**Application by RWE Renewables UK Solar and Storage Limited for the Byers Gill Solar Farm
The Examining Authority's written questions and requests for information (ExQ3)
Issued on 20 December 2024**

Drawing Title
**Figure 2.11
 Typical Access and Supporting
 Infrastructure Layout**

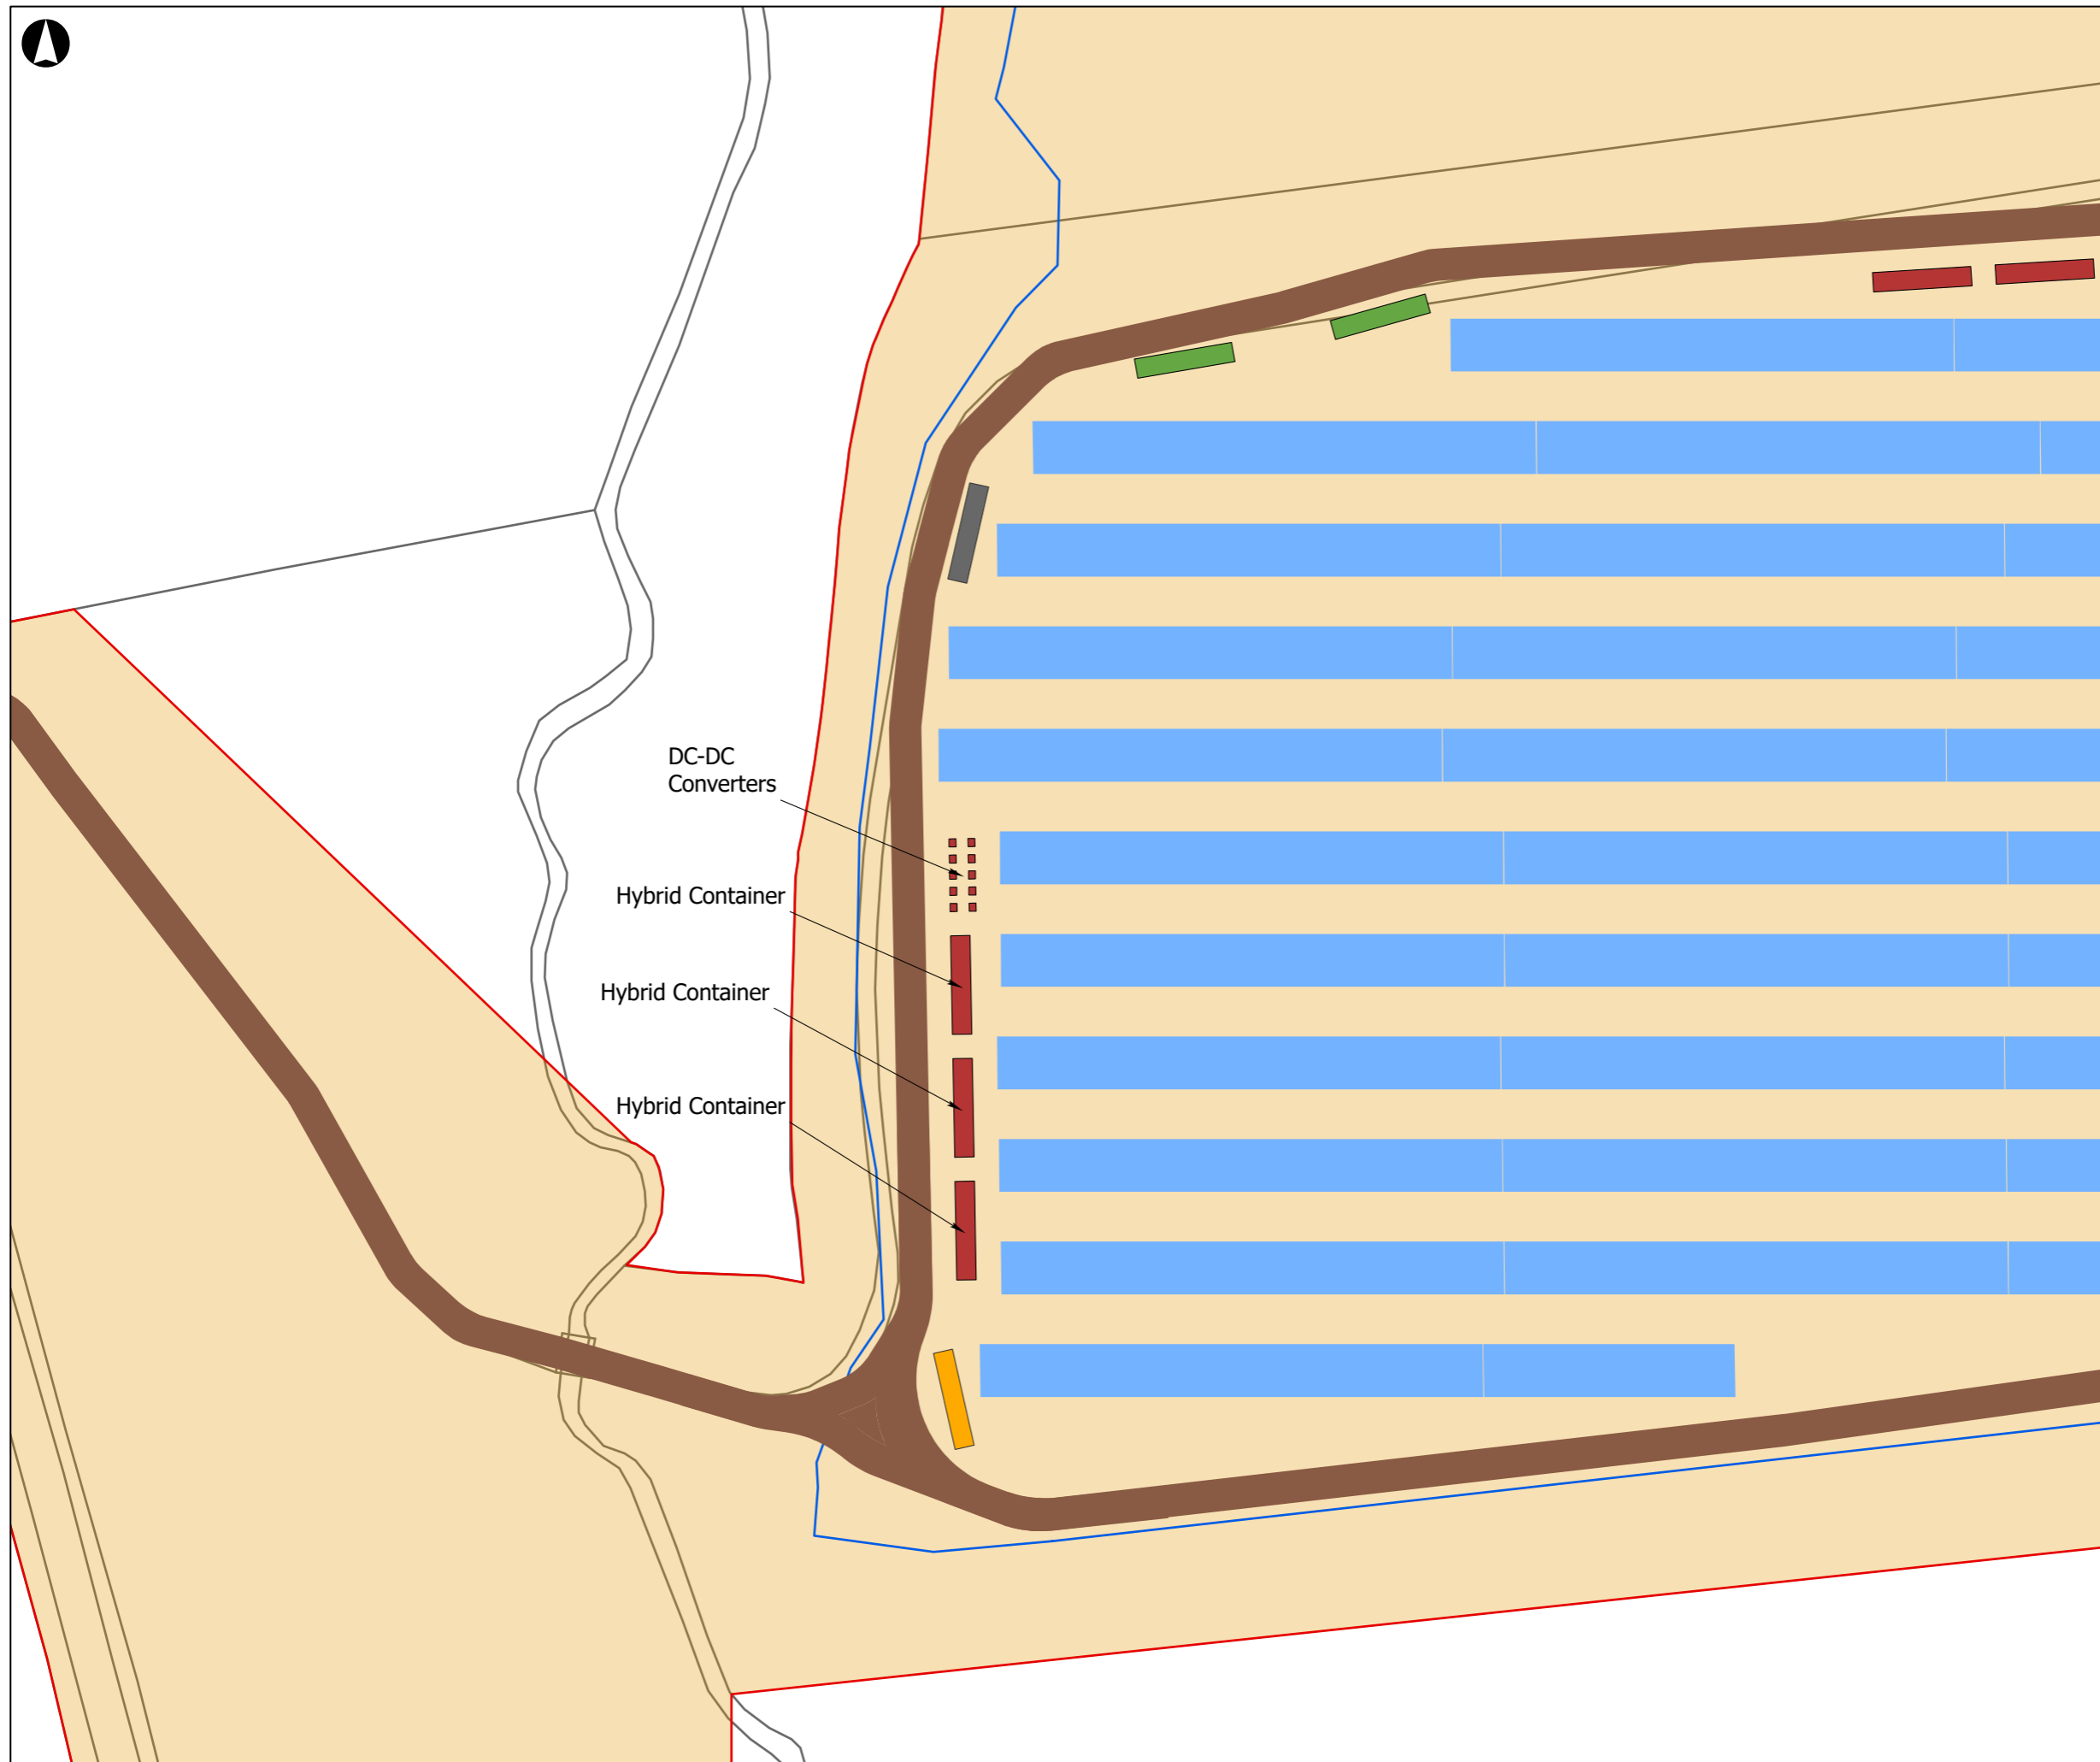
7.	Climate Change and Emissions	
CCE.3.1		No further questions at this stage.
8.	Design	
DES.3.1	Applicant	Paragraph 7.2 of Design Approach Document [REP5-025] states that the distribution of the on-site supporting equipment across the Order Limits which is shown on Plate 7-3 overleaf, has been designed in such a way that it is compliant with the industry safety requirements. Would the Applicant explain the type of industry standard that was applied to the distribution of these equipment?
DES.3.2	Applicant	Paragraph 7.2 of Design Approach Document [REP5-025] also mentions that the Battery Energy Storage System (BESS) has been placed at least 300m from residential properties in the majority of cases, to reduce the visual and noise impact of the infrastructure. Can the Applicant confirm the areas where the BESS would be sited less than 300m from residential properties and what extra mitigations have been proposed to minimise the impact of such proximity of these areas or residential properties to the BESS?
